KITTITAS COUNTY DEPARTMENT OF PUBLIC WORKS

MEMORANDUM

TO: All Staff
FROM: Public Works Plan Review Team
DATE: July 28th, 2023 Updated 12/23/2024
SUBJECT: Public Works Comments: BL-23-00014 Suncadia Resort LLC

DRAWING NAME : ESM\ESM-JOBS\998\807\020\SURVEY PLOTS\P3D17-BLA1-01.DWG

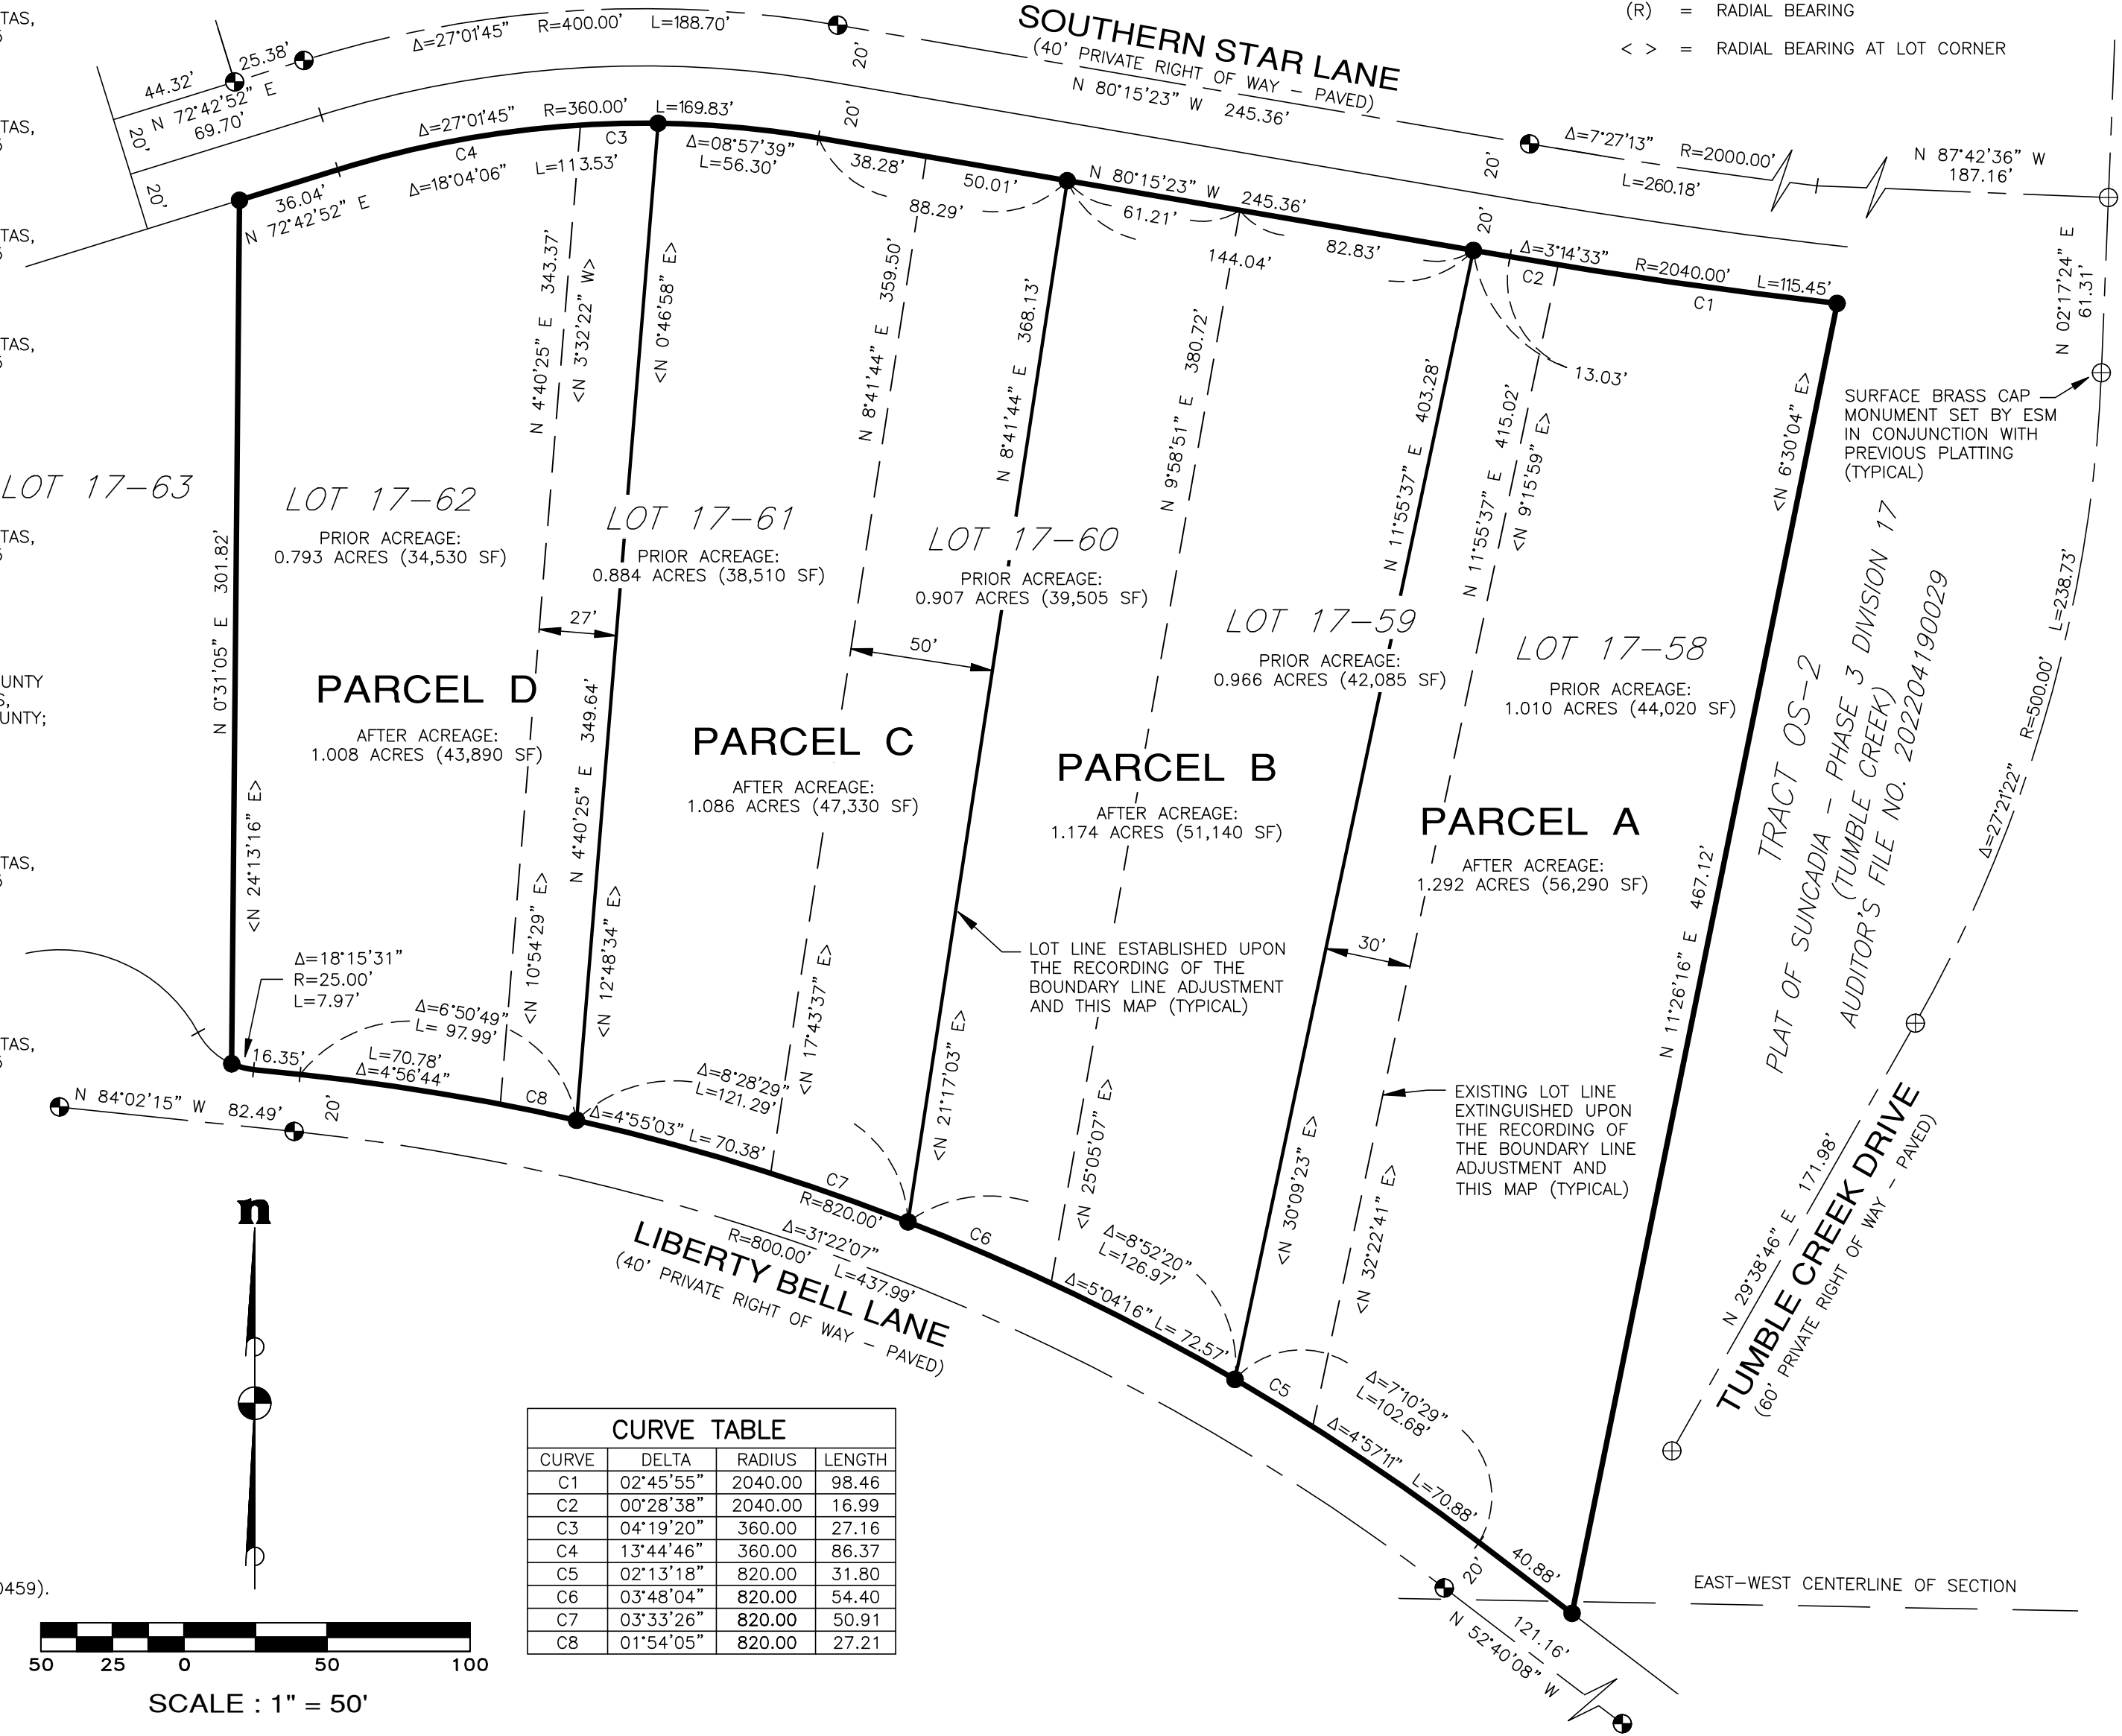
ACCESS	No Comments (TM).
ENGINEERING	No Comments
SURVEY	Survey comments below reflect requirements for Final Survey submittal. 1. Show existing survey control utilized to establish new set corners. 2. Provide Lot Closure reports for new boundaries. (JT) UPDATE 12/23/2024 The most recent submittal has addressed all prior Survey Comments. (JT)
TRANSPORTATION CONCURRENCY	No Comments
FLOOD & WATER MITIGATION/ METERING	No comments. (SC)
